MEMORANDUM

From: Steve Long  
To: Jean Fraser, Planner  
Date: December 4, 2012  
Subject: Commercial & Maple Street Mixed Use Development – Responses to Comments

### **Zoning comments from Marge Schmuckal dated 11/08/12**

### **Department of Public Services comments dated 11/07/12**

STORMWATER PLANTER PLAN  
SCALE: 1 INCH = 3 FEET

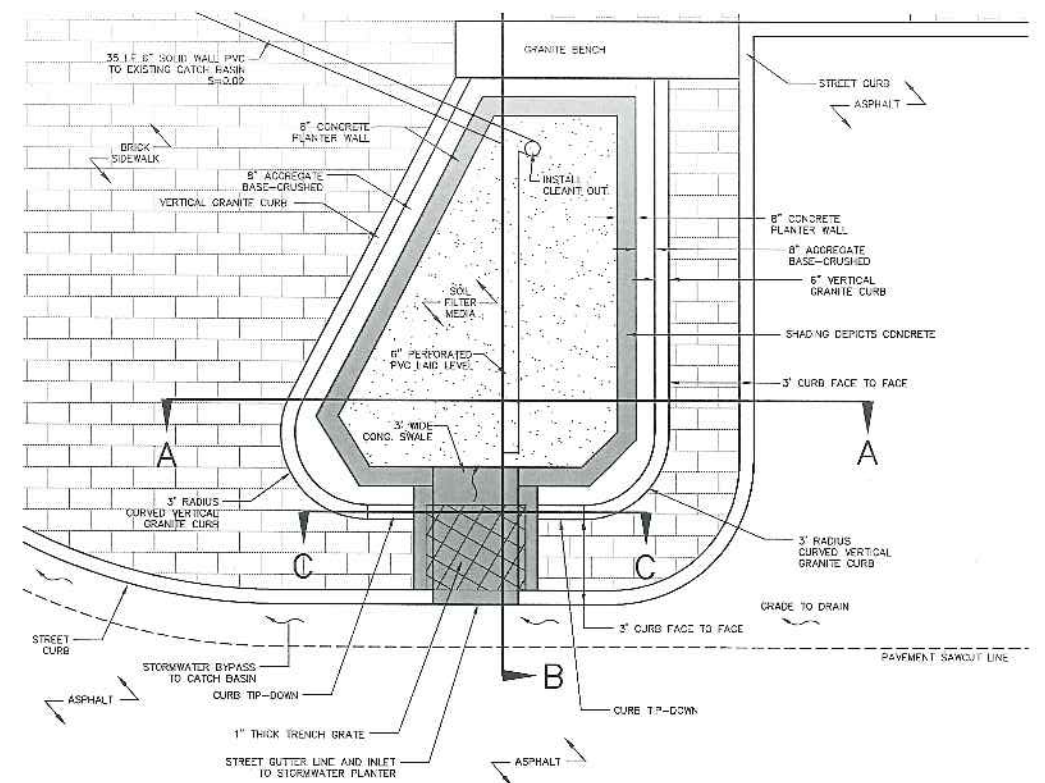
***Details and notes will be added to the final plans indicating how the contractor will plug and abandon existing pipes.***
3. It would be desirable to use portion(s) of the proposed bump outs for green area stormwater treatment.

***A green area stormwater treatment area is now being proposed within the bump out at the Commercial Street site entrance. Please see attached plan showing the treatment area and the area to be treated.***

DATE:	10-22-12
SCALE:	1"=20'
DRAWN BY:	BJS
C03	
SHEET:	3 OF 13

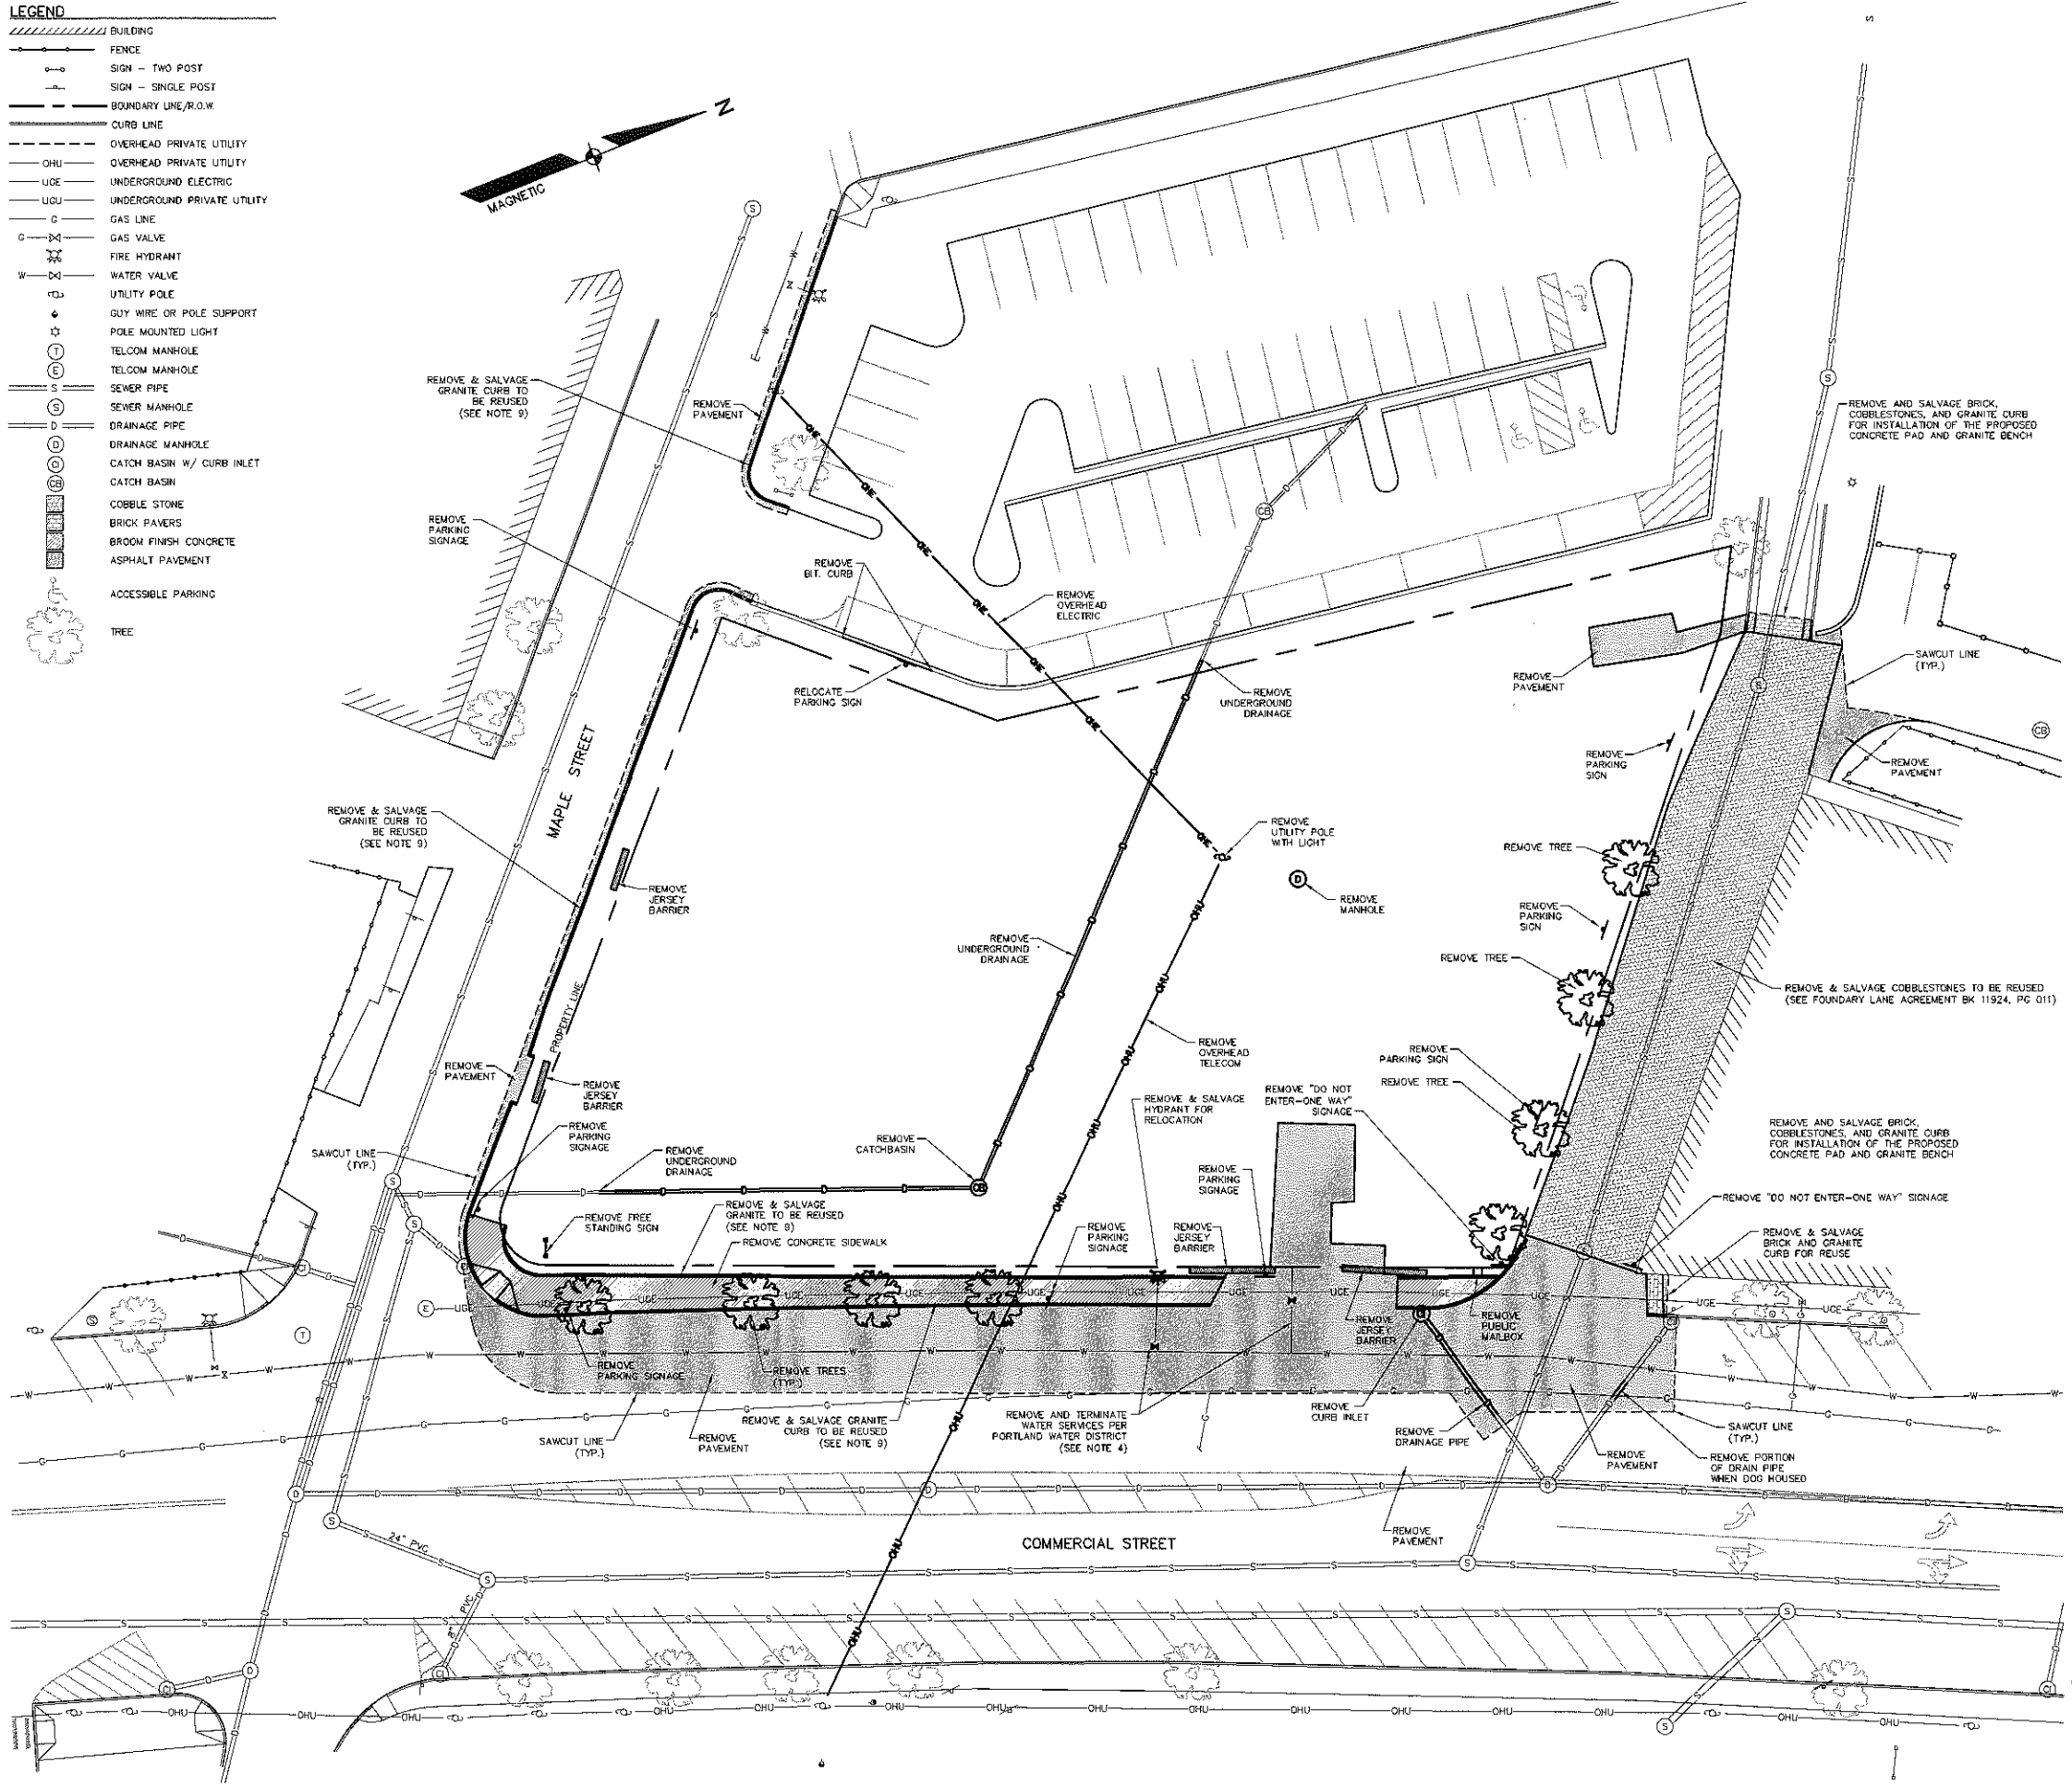
***A waiver request has been submitted.***
- The painted areas at the driveway entry on Maple Street should be removed.  
***There is a plan label on the Site Plan indicating that parking spaces along Maple Street are delineated to show quantity and location of spaces. Do not paint.***
